PLANNING AMENDMENT

H08/0089/01

Plot 1, Apple Crumble Court, off Belchmire Lane, GOSBERTON

Amendments to Living Room size
and Bedroom over (Reduction)

Drawing No.
210418

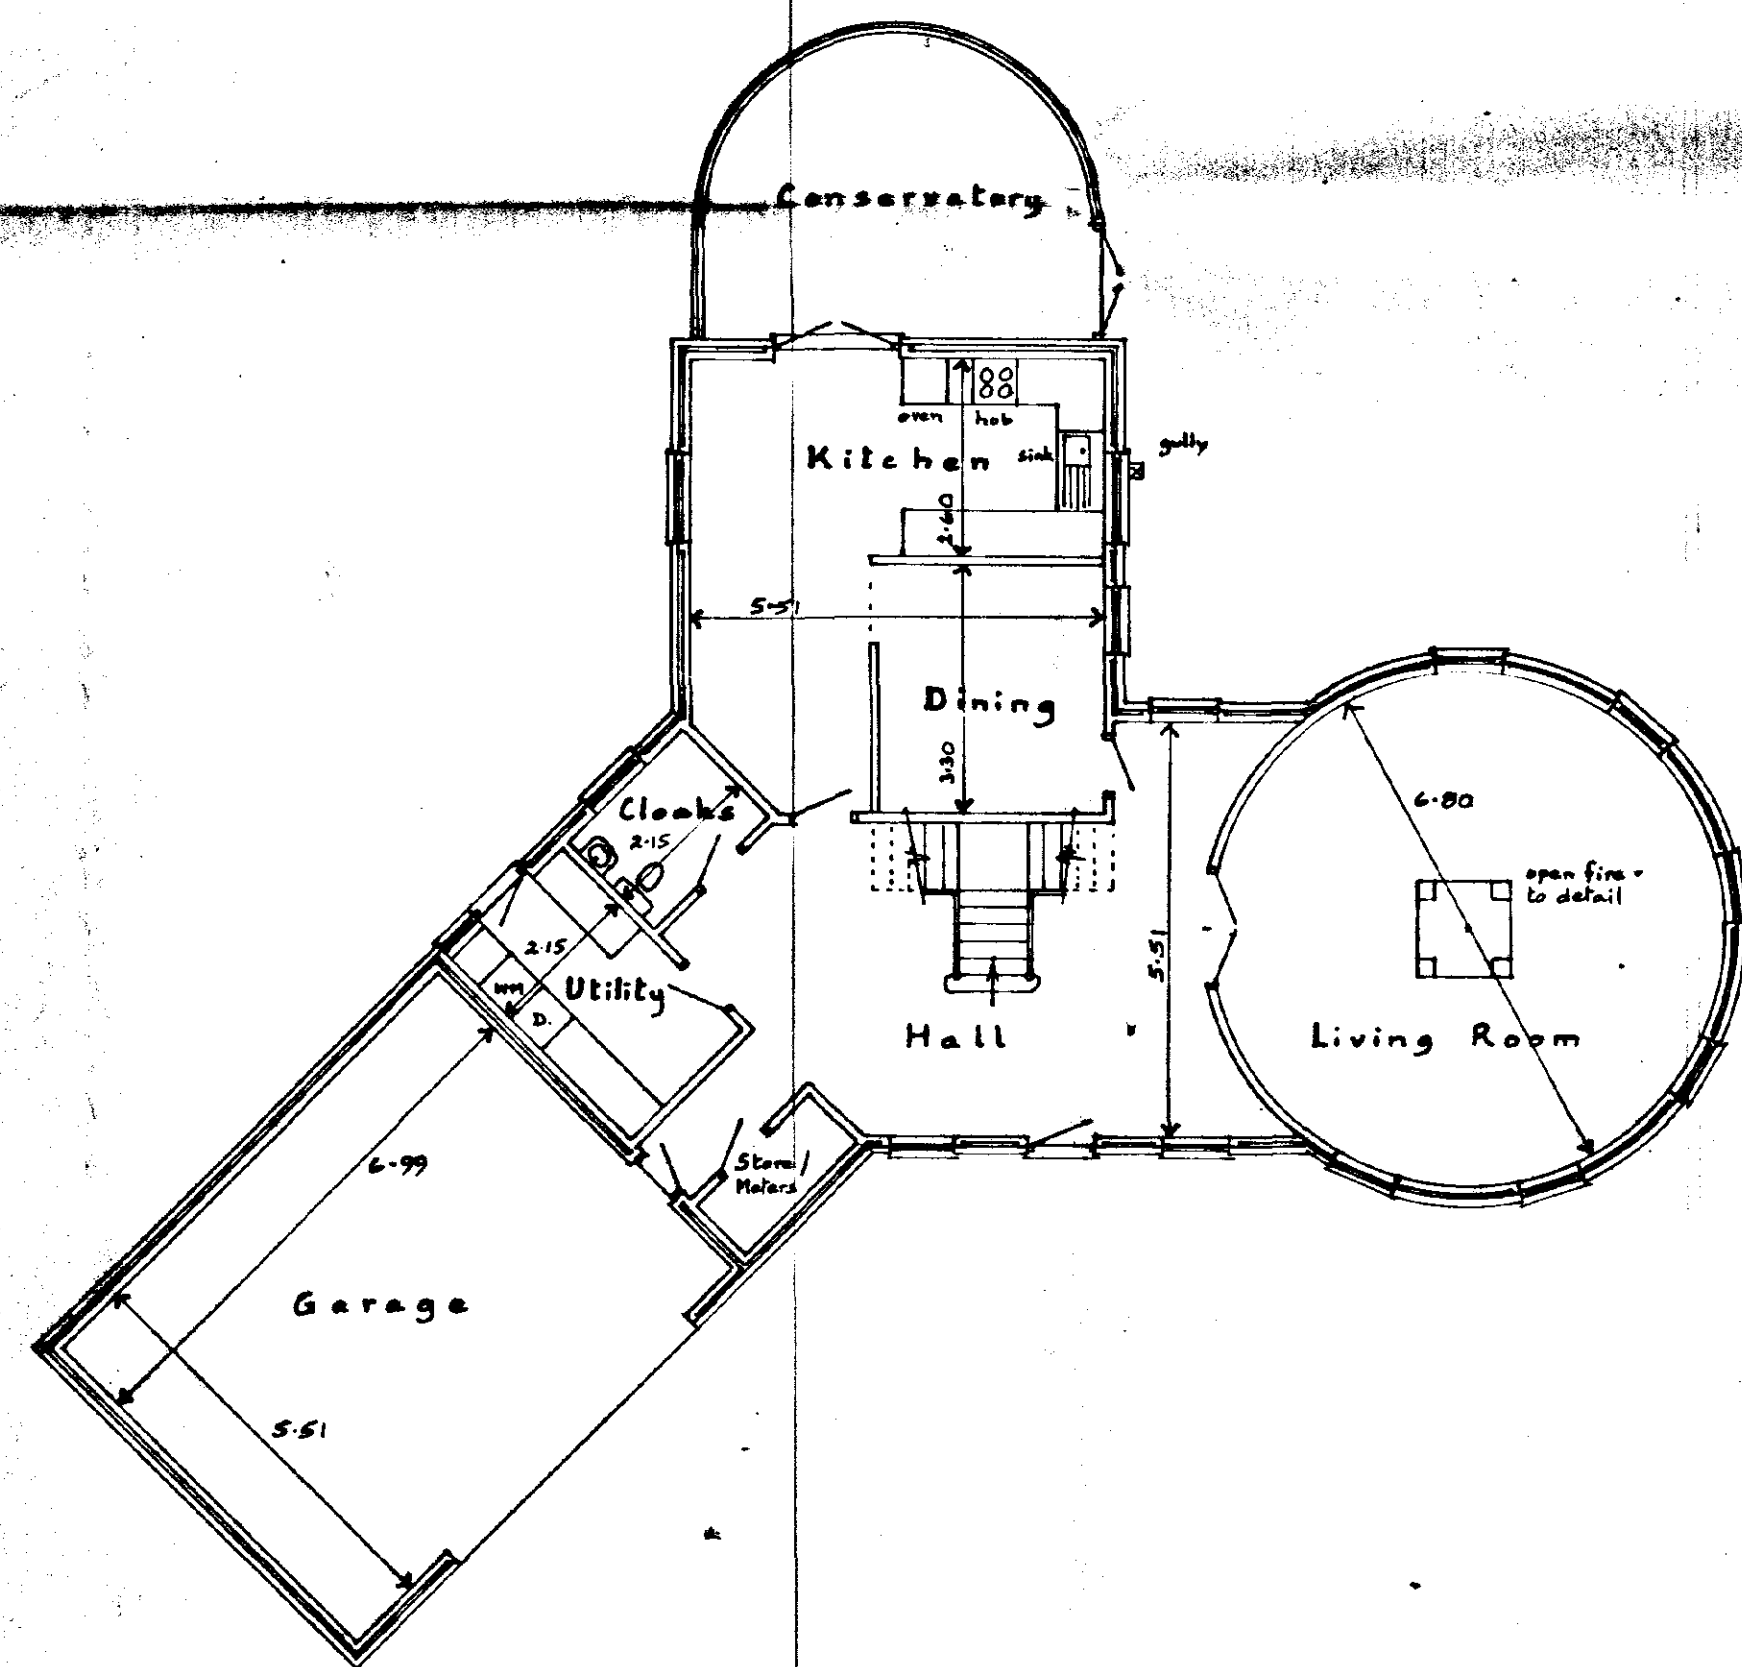
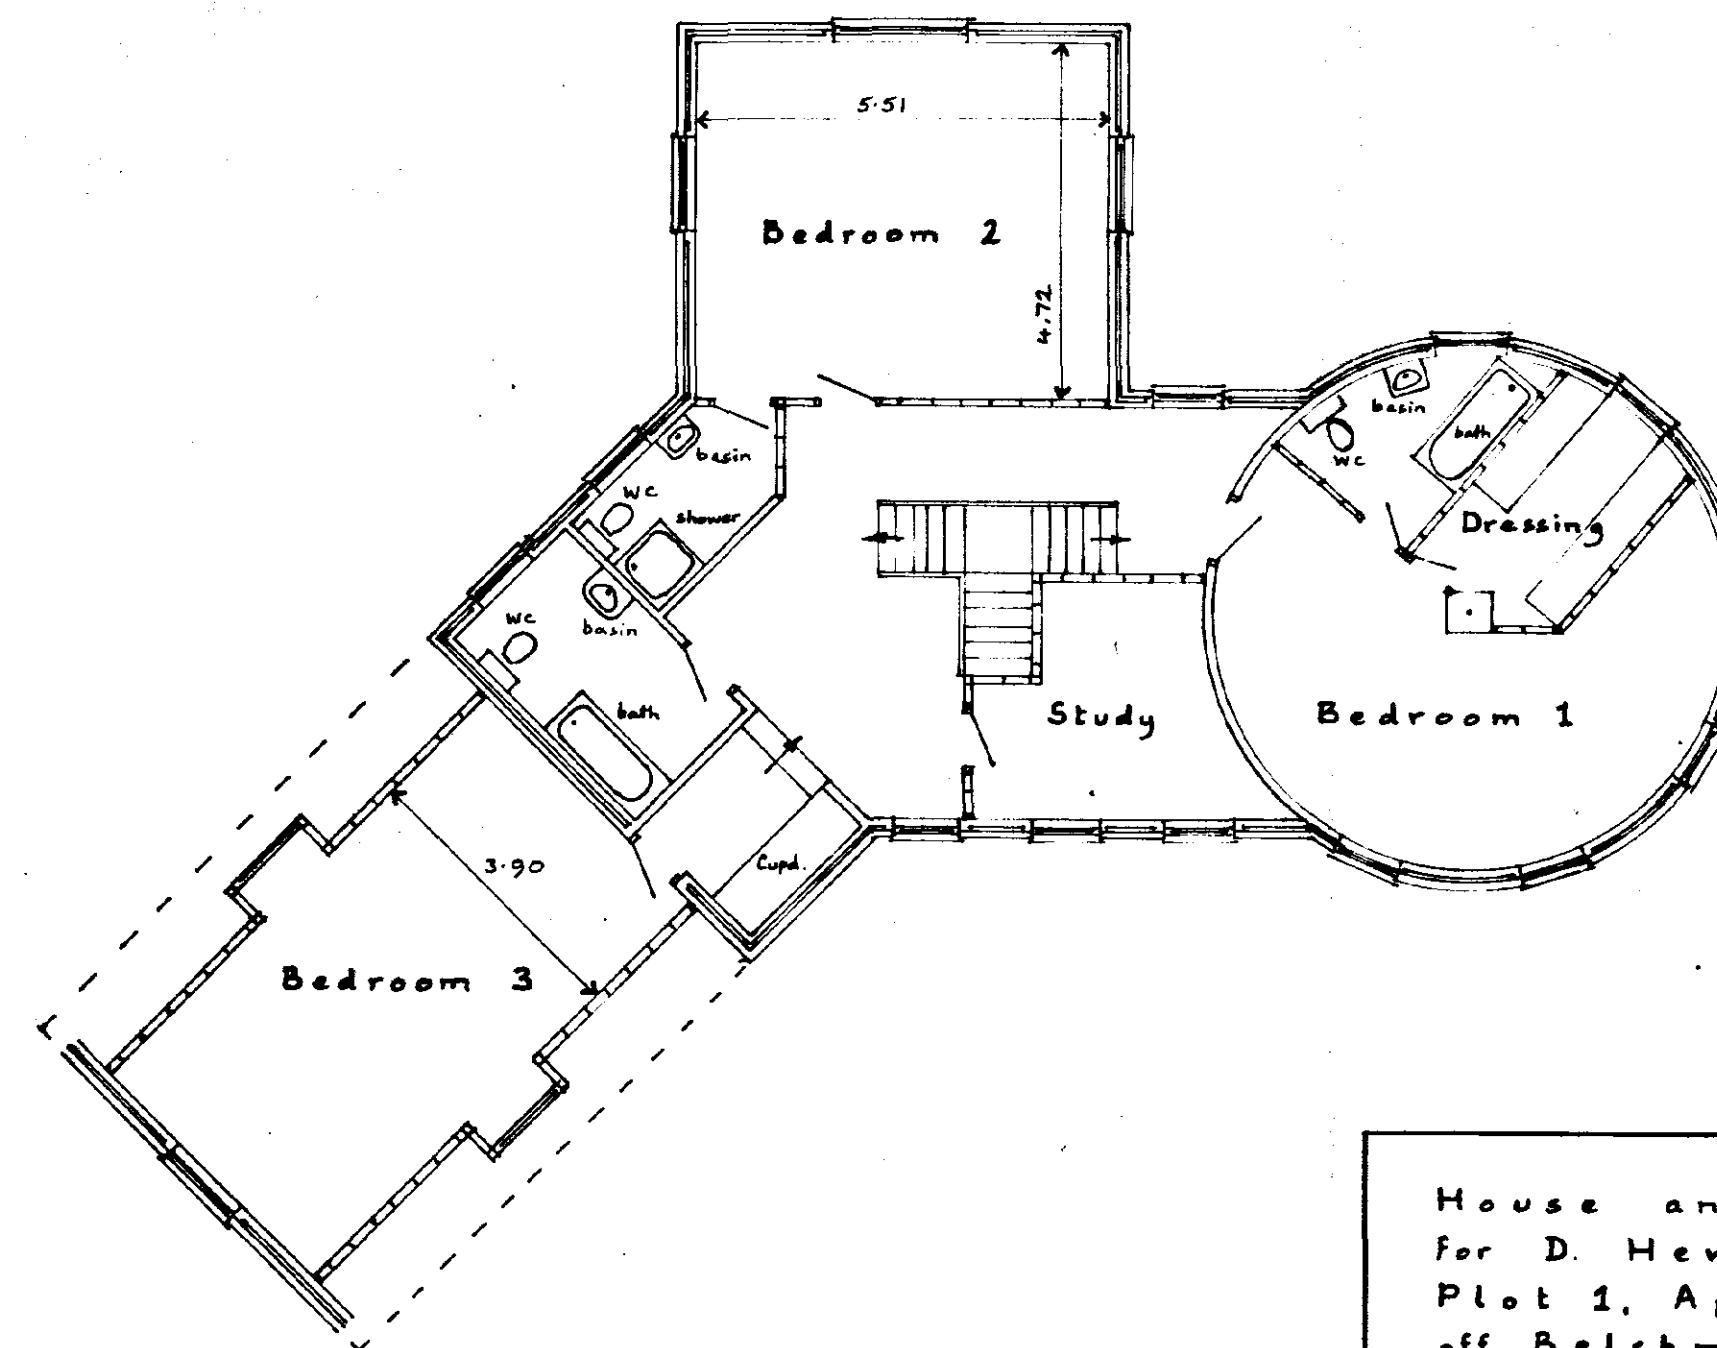
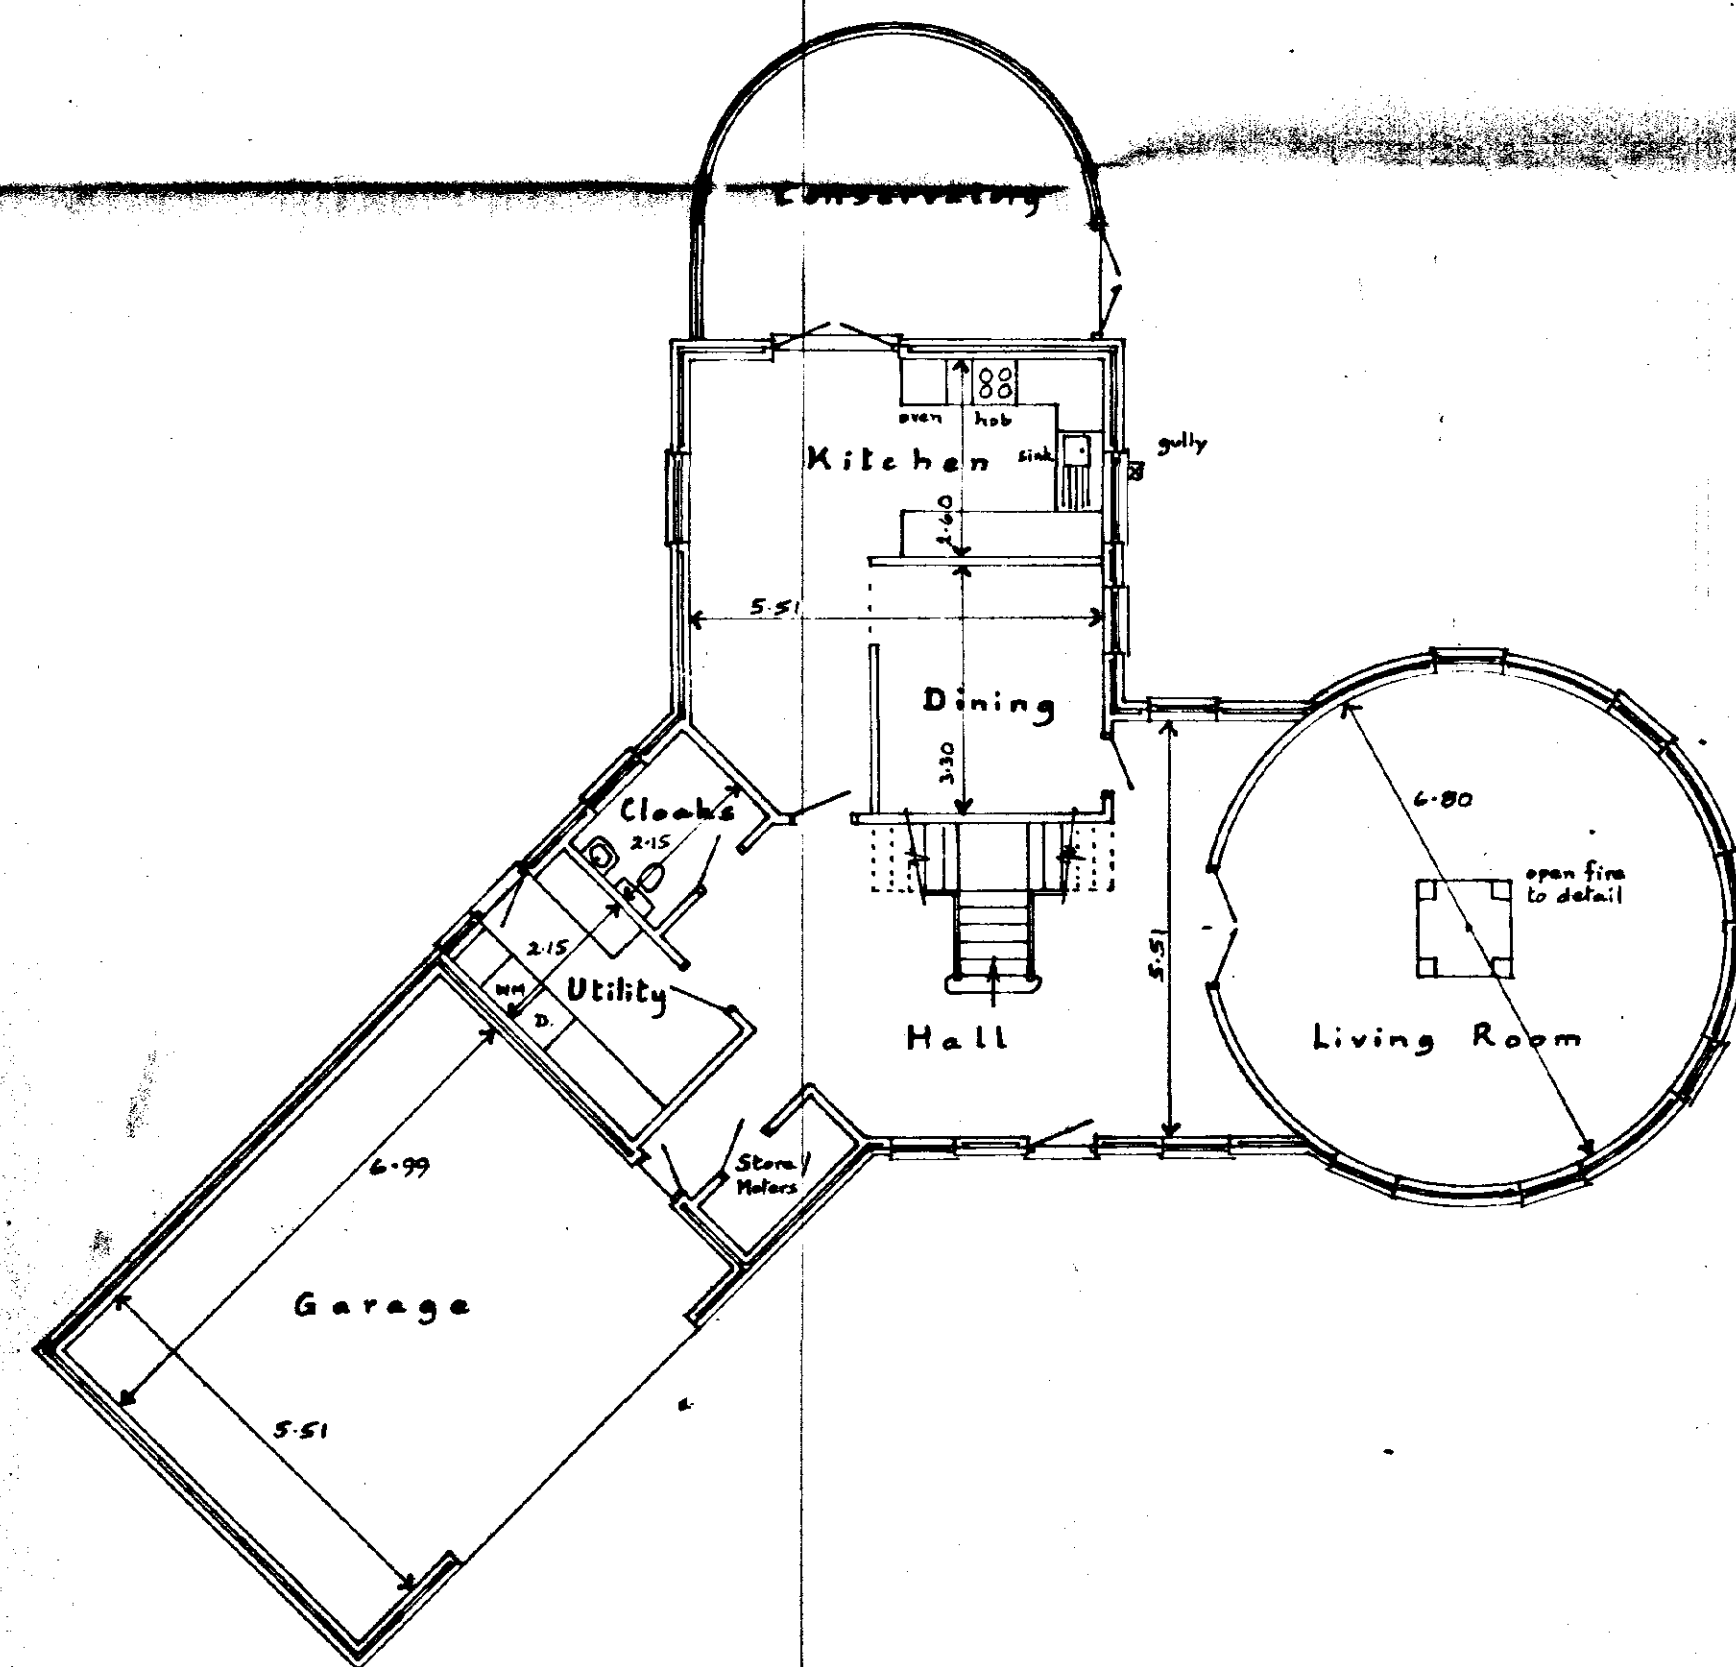
Amendment: Amendments to living room size and bedroom over
(Dwg nos. 210418 & 201113A)
